Town & Country Planning (Control of Advertisement) (England) Regulations 2007 (as amended)
Application for Consent to Display an Advertisement(s)

Development 2 No. fascia signs & installation of LED trough light to East Elevation

Location Martin McColl 5 High Street Arundel

TMRETAIL\SITE FOLDERS\6242 Arundel High st/
6242 Arundel high st new image 7 incl troughlights

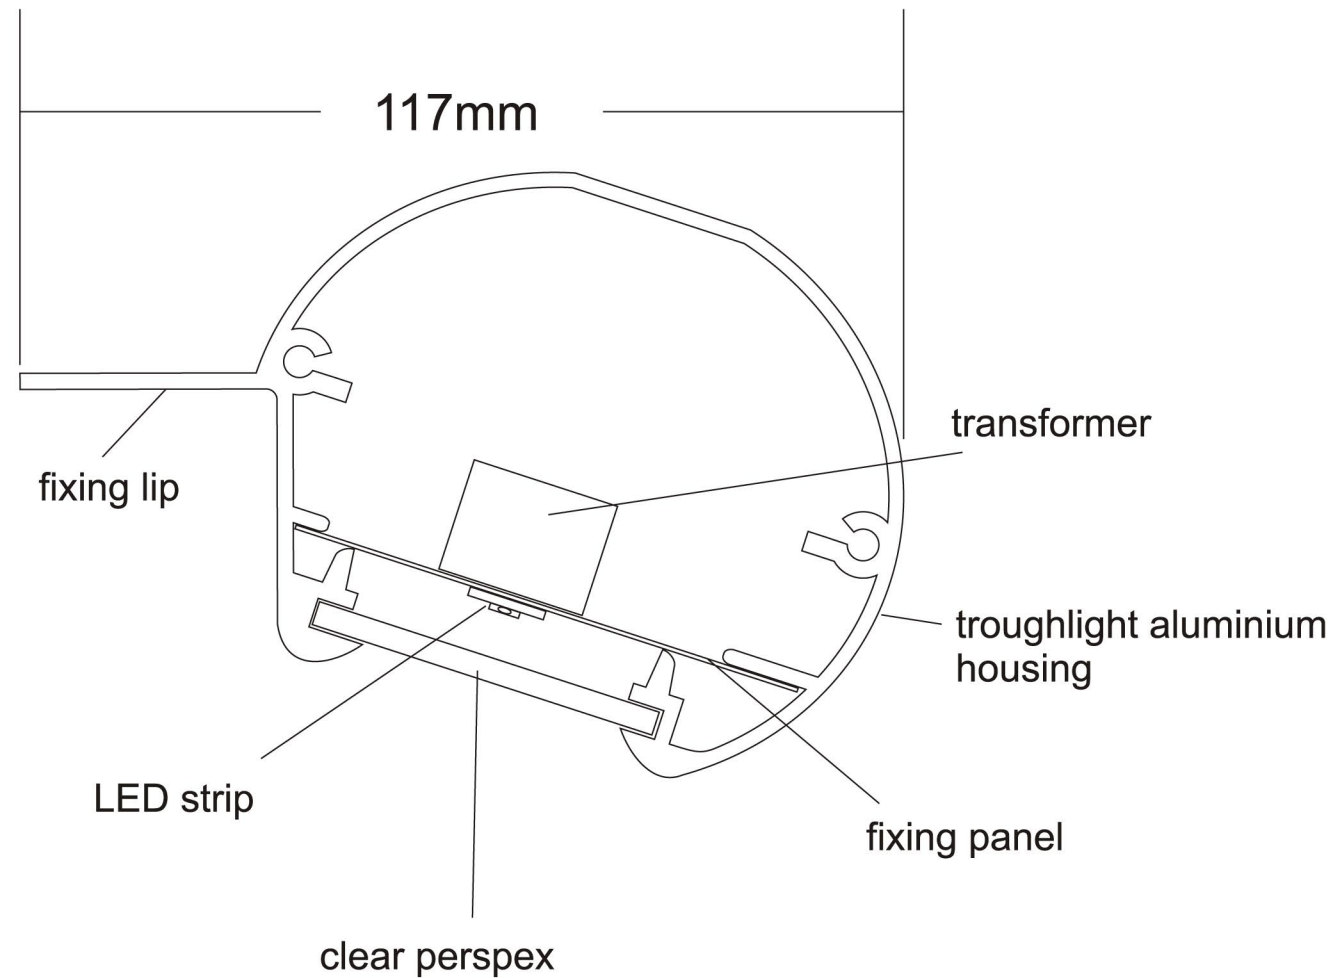
Please confirm in writing if the projecting sign forms part of this application, if does then please clearly show the position on the Block plan and provided dimensions of the sign. If the projecting does not form part of the application then please remove it from the plan No. 7.
